Hornsby Ku-Ring-Gai Hospital Stage 2 – State Significant Development Project (SSD 8647)

Response to Submissions Report
NSW Health Infrastructure
26 February 2018

Response to Submissions Report – SSD 8647 – HKH Stage 2 Redevelopment

Noise Monitor Along Derby Street: Sunday 28 May, 2017

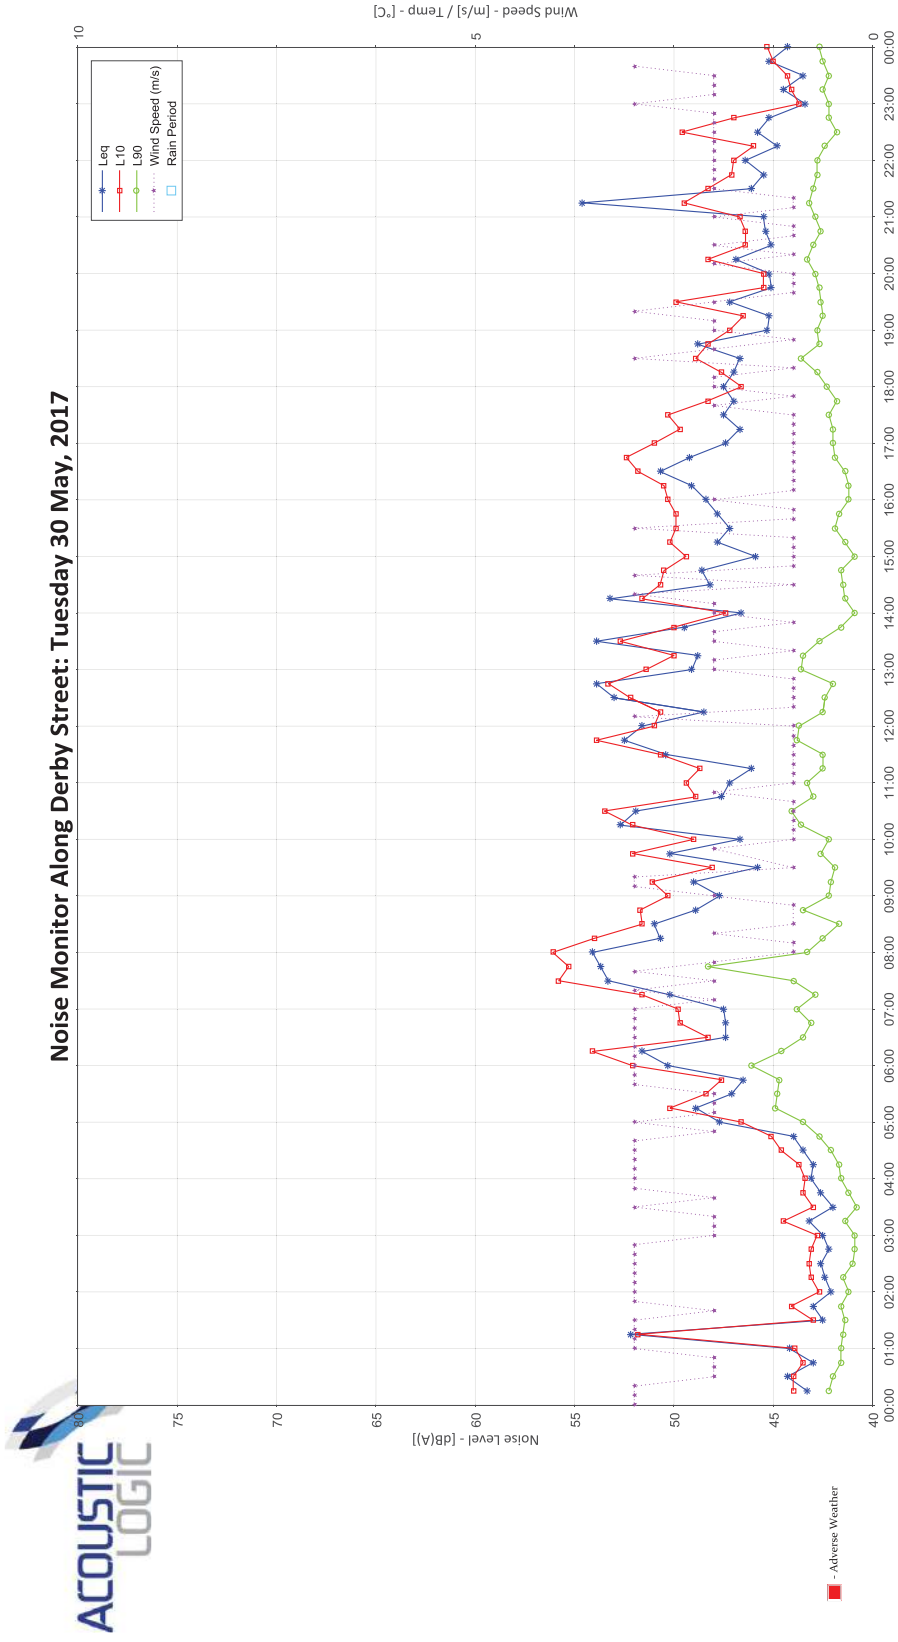
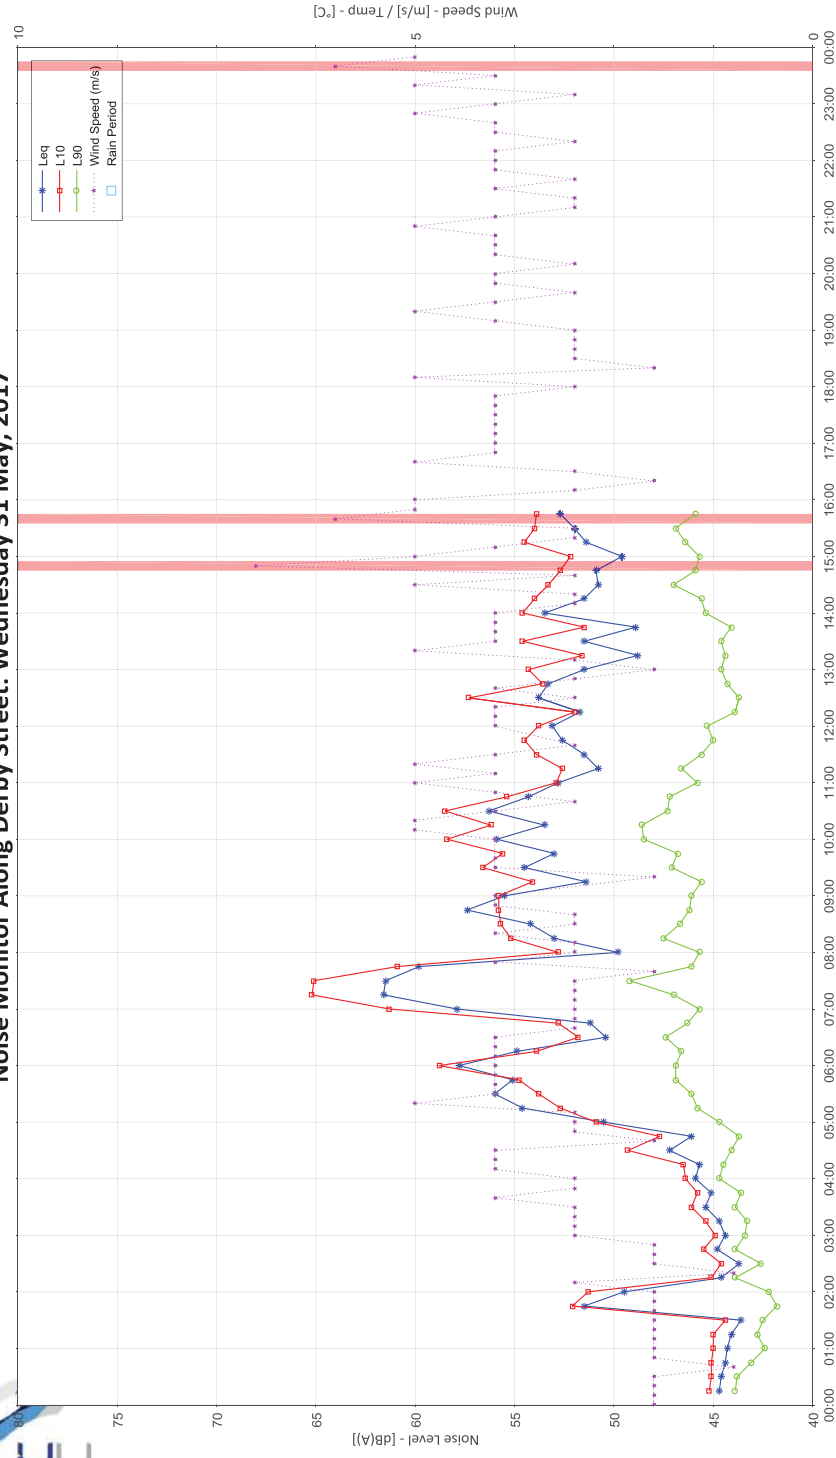
3.17	NSW EPA	A potential error in Appendix 2 (titled Noise Monitoring Along Derby Street) of the SSD Acoustic Assessment was noted by the EPA where the Burdett Street noise monitoring data had been inserted rather than the Derby Street data.	As per Item 3.15 .	Appendix J – Revised Noise Impact Assessment
